Planning Reference: 2025 / 0915 Barnsley Hospital VIE Liquid Oxygen Compound

Further to comments received by Senior Urban Design Officer on the 14th January 2026 please see below for responses.

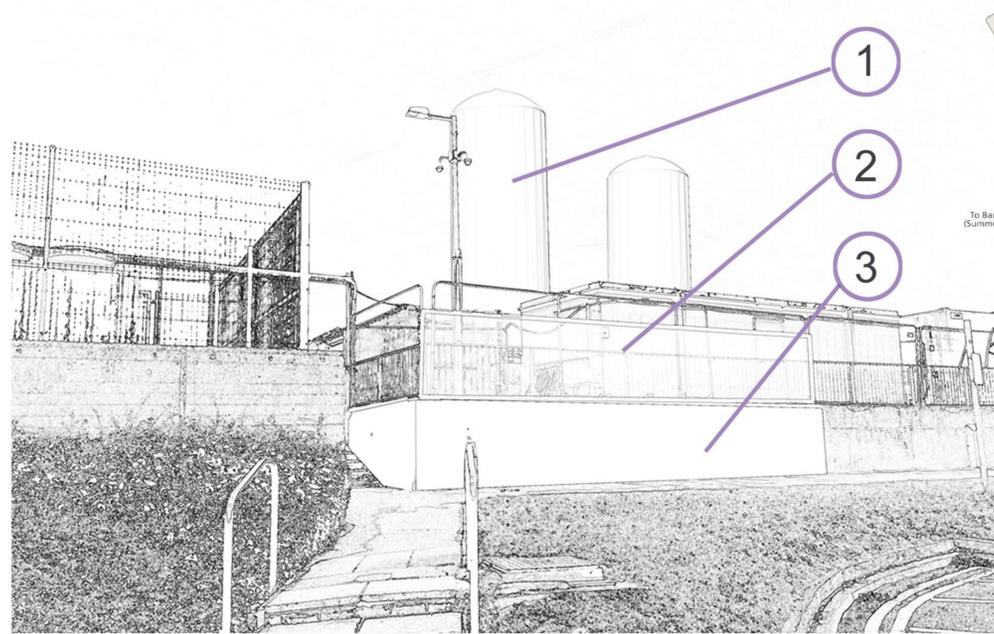
10, Corten screen design will feature highly perforated panels and pattern to prevent it looking overly imposing on the pedestrian route and existing lighting will be modified to provide extra lighting in evenings and night time.

13, Artwork to BOC liquid Oxygen Vessel will be painted and not 'wrapped' with vinyl transfer due to texture of surface.

AXONOMETRIC 3D VIEW 1:100_

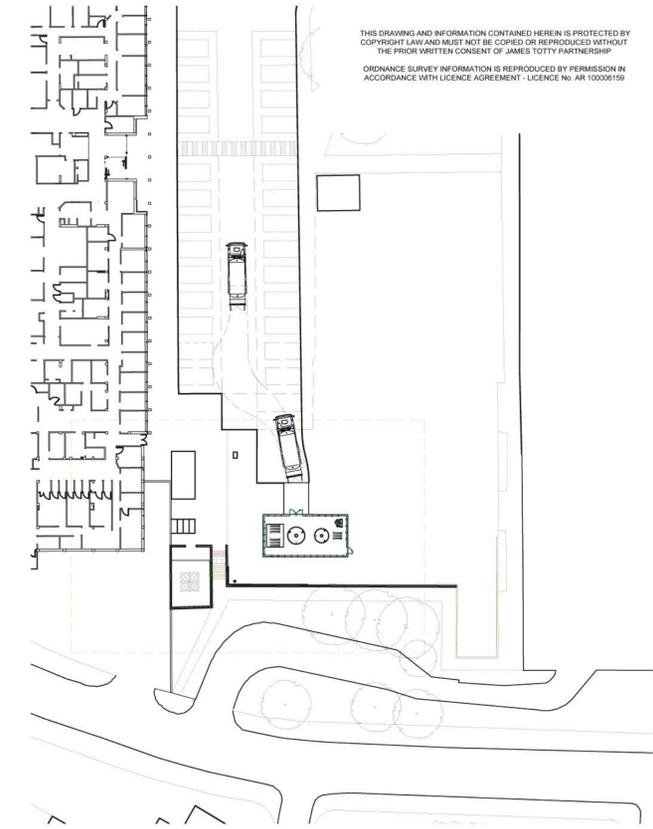
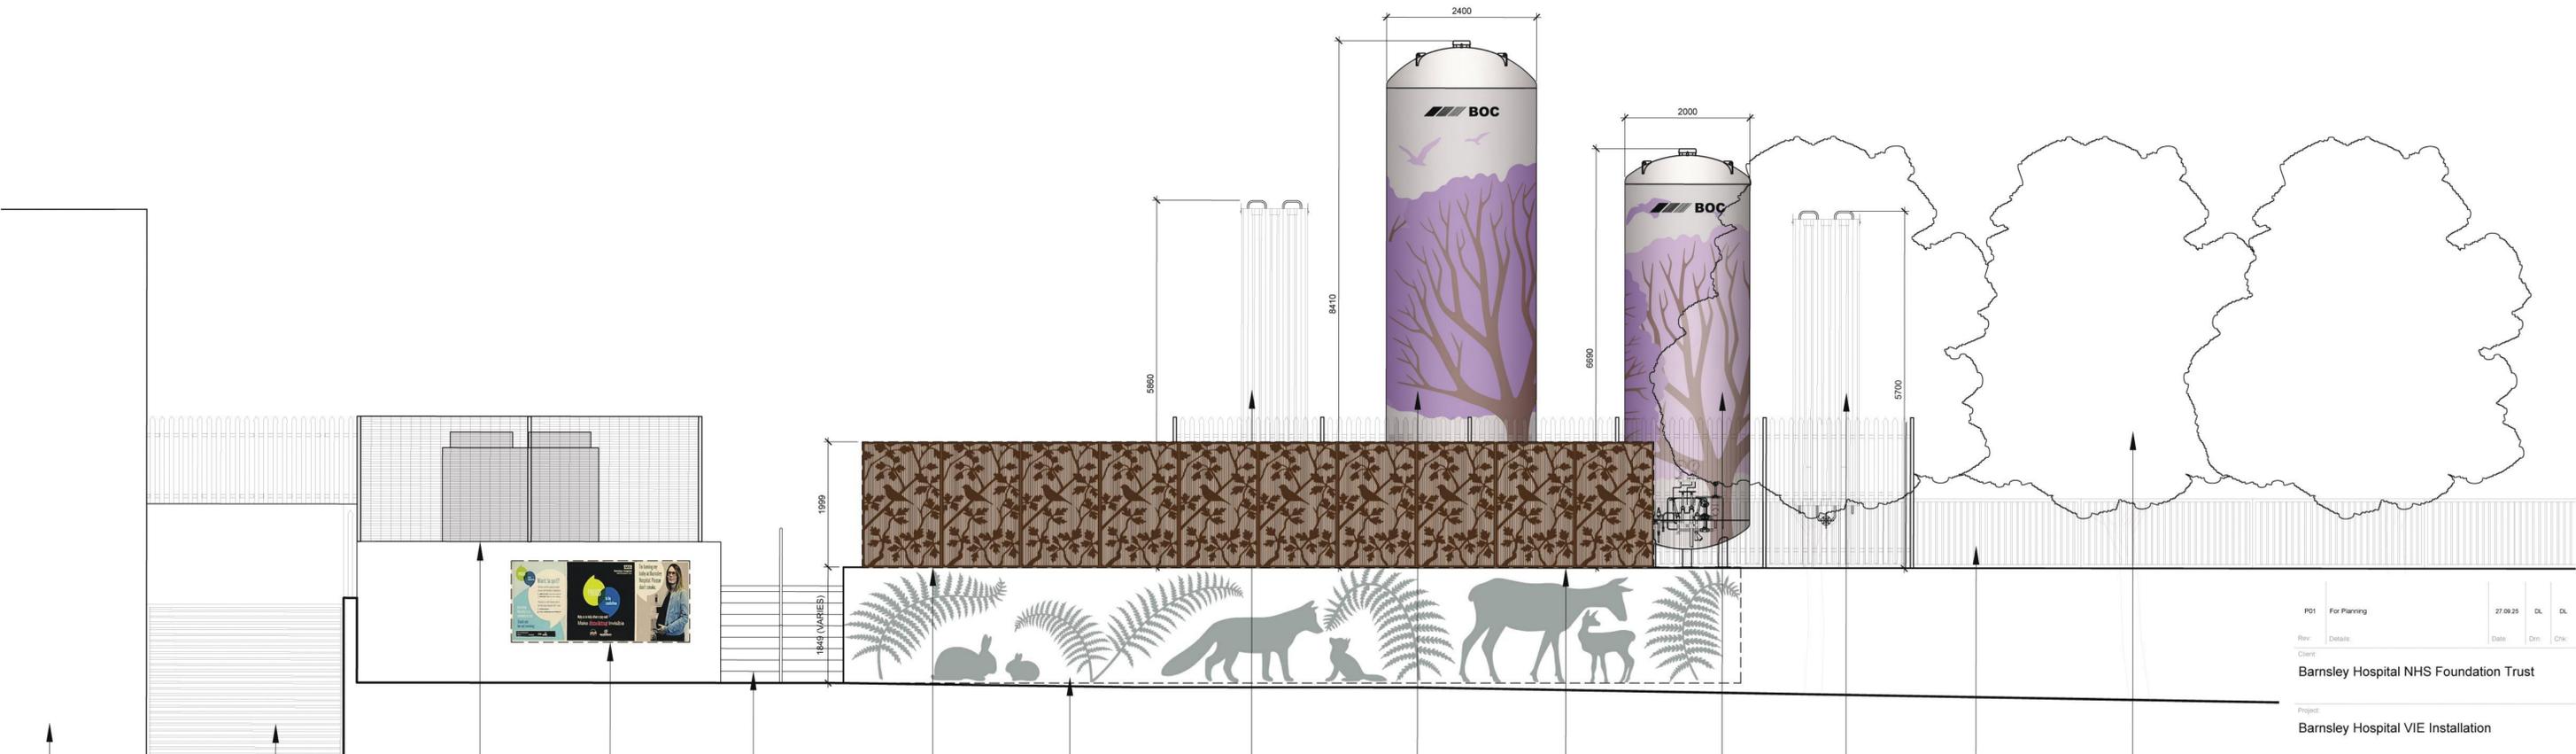
2, Existing railing to perimeter of retaining wall will remain except where new Corten screen is to be located and added to site plan and elevations.

Note, following comments relating to potential security and anti-social behaviour the proposed new Corten screen has been moved to the corner of the site, in line with the retaining wall to prevent people from hiding on the wall side of the screen.

9, Corten screen to be 2 metres high and drawing showing 2.4m has been corrected.
